February 24, 2016

Re: Site Plan II Application Response to Traffic Comments
Proposed Taco Bell, 1363 Washington Ave, Portland, ME

Traffic Engineer Peer Review

Not Approved for Construction
Drawing Title
Layout & Materials

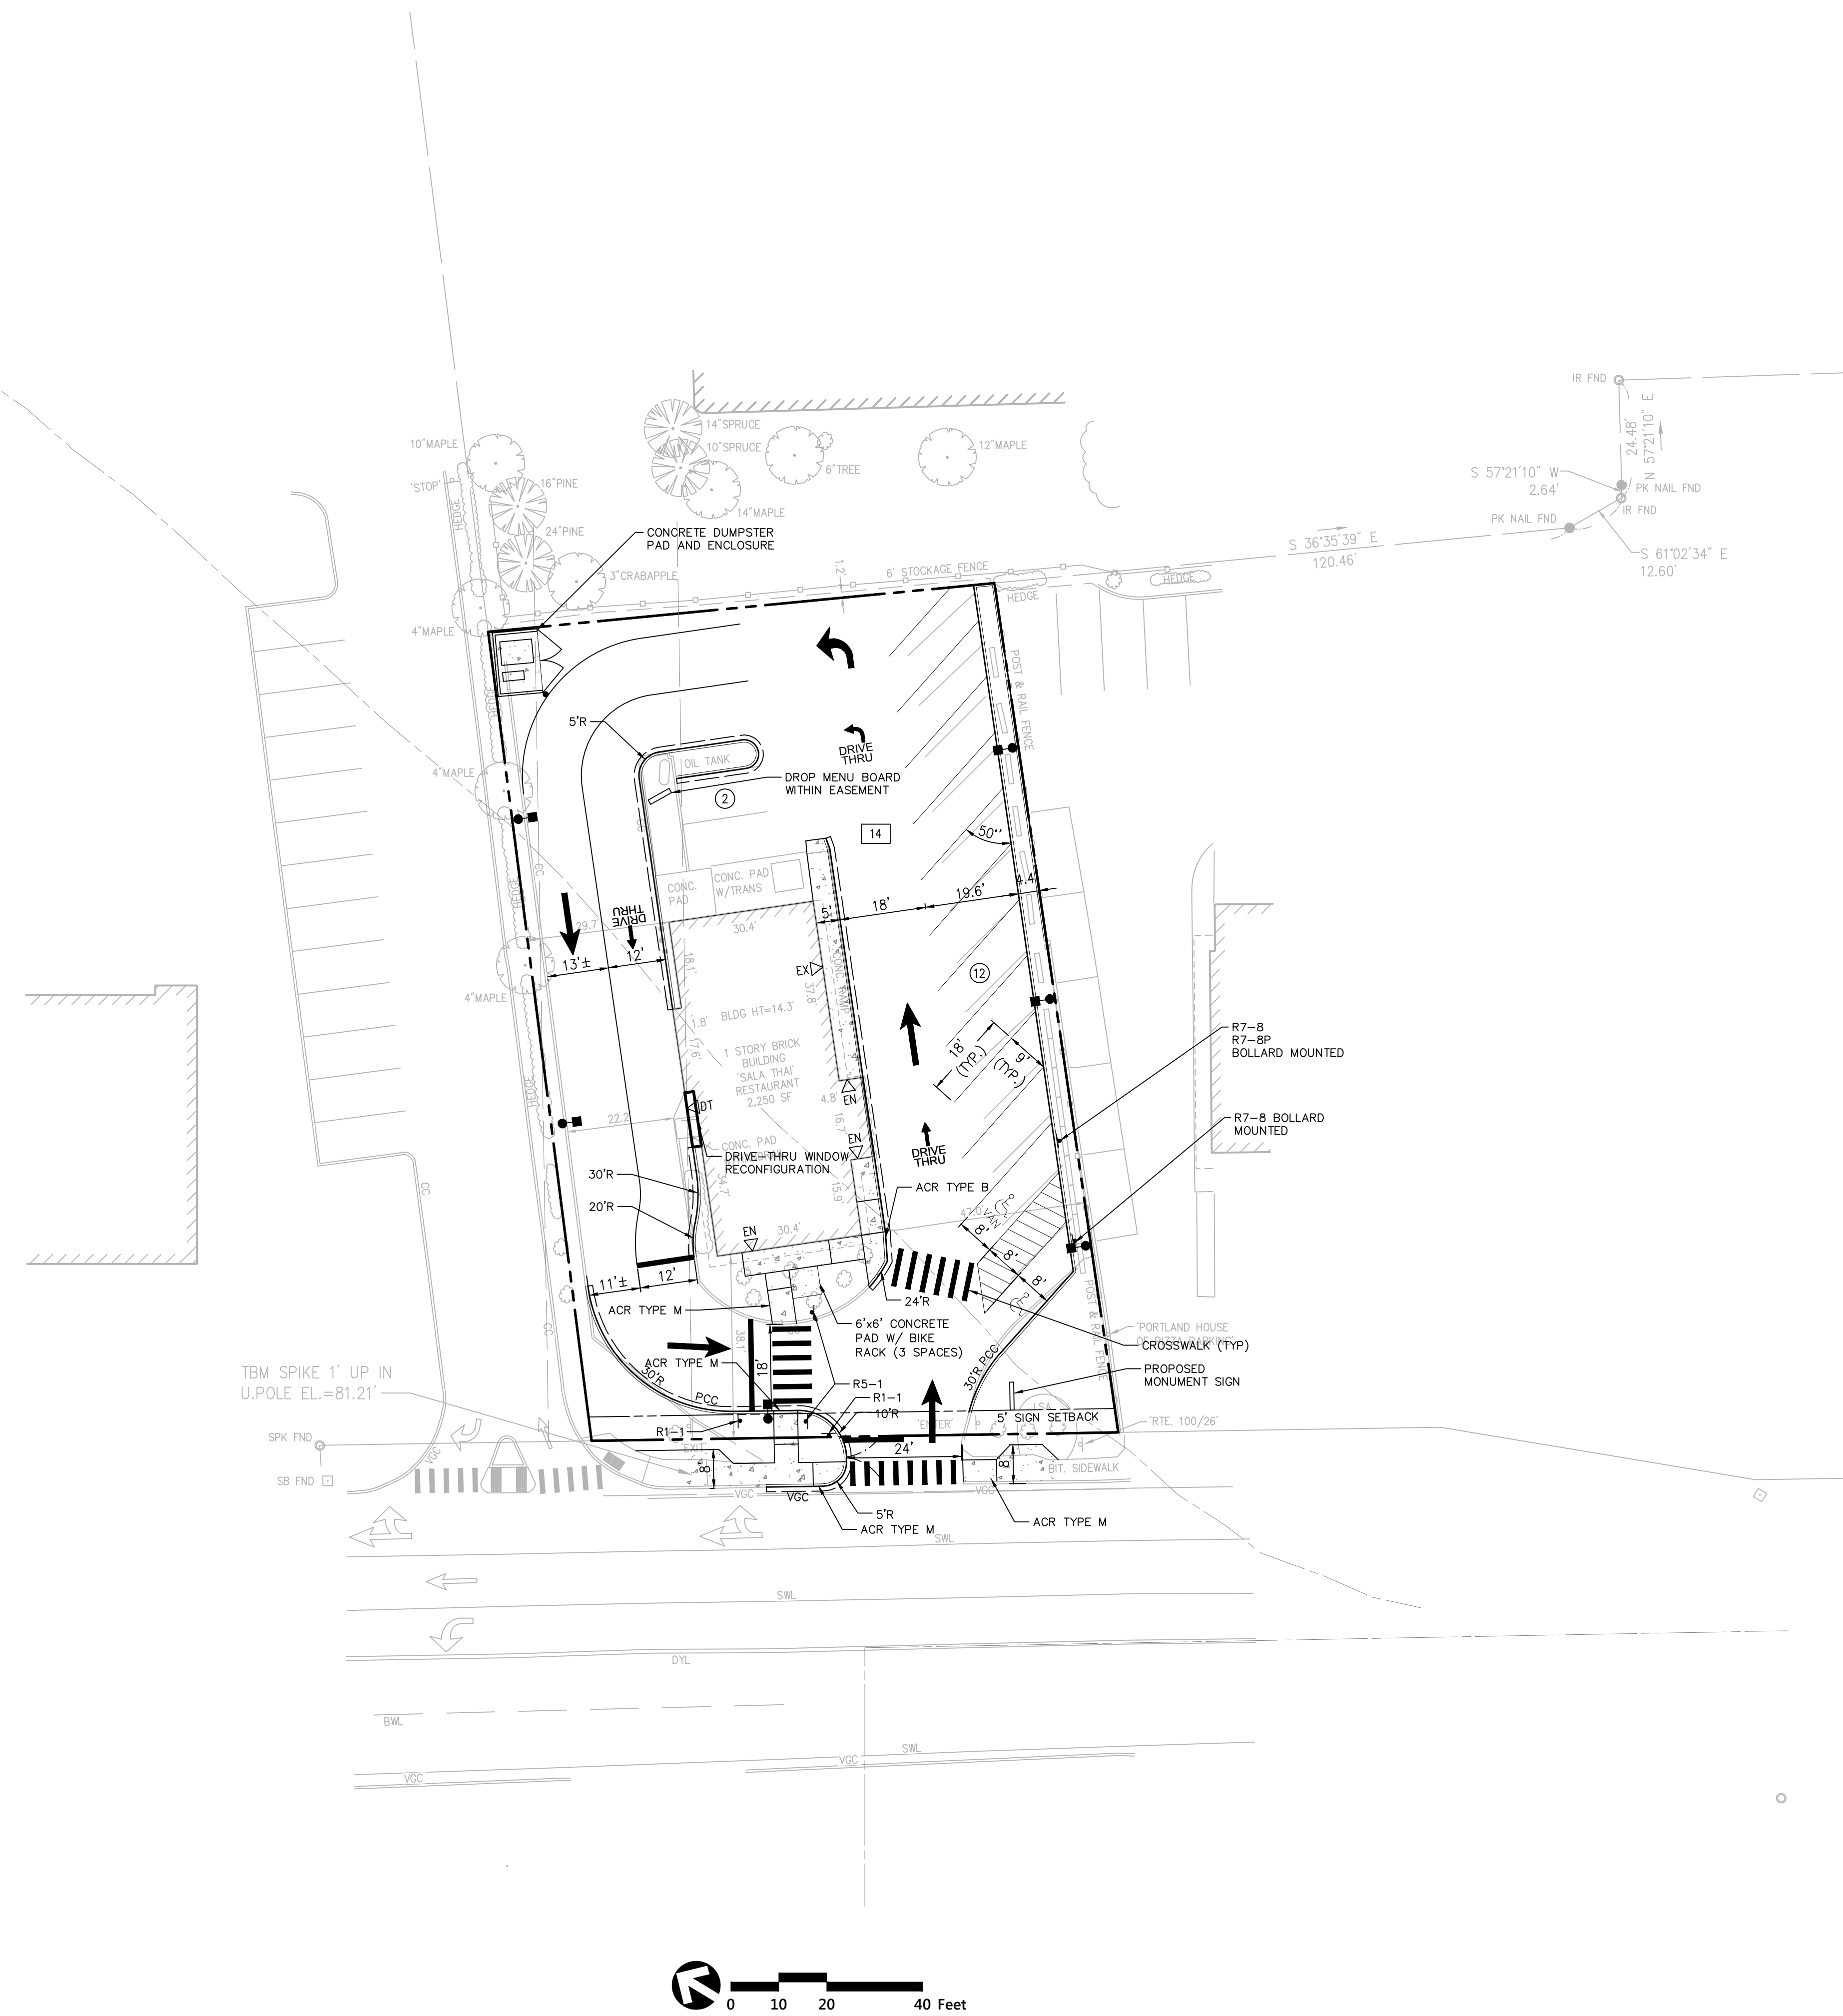
- 5. Sidewalk improvements along the property frontage on Washington Avenue shall be included. Two utility poles are located in the sidewalk and their location obstructs pedestrian accessibility. I would suggest the sidewalk be widened toward the site to accommodate a 5-foot clearance to the face of poles.*

- 6. The applicant should document whether the proposed driveway meets City's driveway separation standards. If the driveway does not meet separation standards, the applicant should formally request a waiver with supporting documentation.*

- 7. The applicant should provide dimensions for all on-site parking lot elements and note whether City standards are met.*

The sidewalk along Washington Avenue has been widened to 8-feet to provide appropriate accessibility around the two existing utility poles.

The site will be utilizing an existing driveway. The driveway is located approximately 52-feet from the Dunkin Donuts across the street and approximately 59-feet from the Portland House of Pizza driveway. The applicant will formally request a waiver as needed.

Dimensions have been added to the plans. Per the City's standards angled parking is shown for 45-degree and 60-degree stalls. In order to provide a 4-foot minimum landscaped island on the southeast property line, 50-degree parking stalls have been proposed with an 18-foot drive aisle.

**BICYCLE RACK SPECIFICATION - BIKE HITCH**  
 N.T.S. Source: VHB LD\_533a

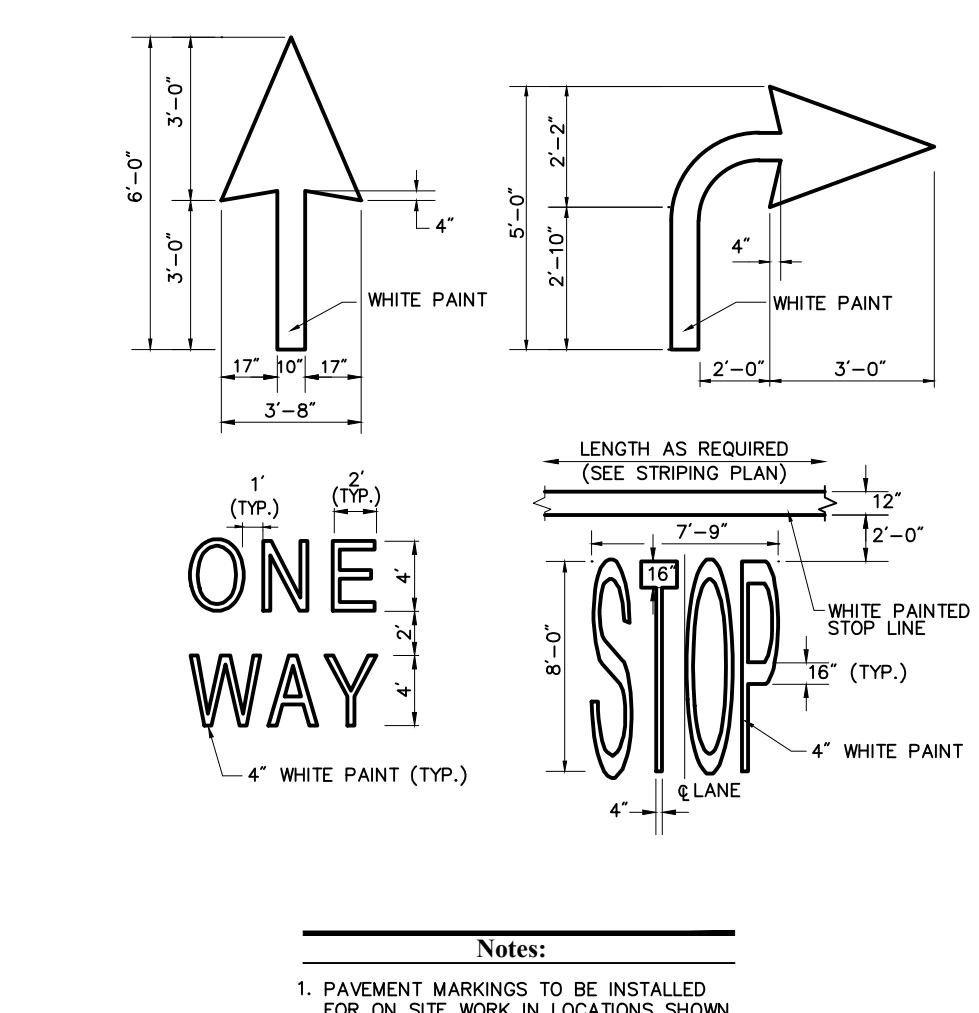
- 4. The applicant should provide bike racks on-site that meet City standards.*

The proposed site requires a bike rack for 3 bikes per City standards. A rack for 3 bikes will be added to the plans, the final location of the bike rack is to be coordinated with the Applicant.
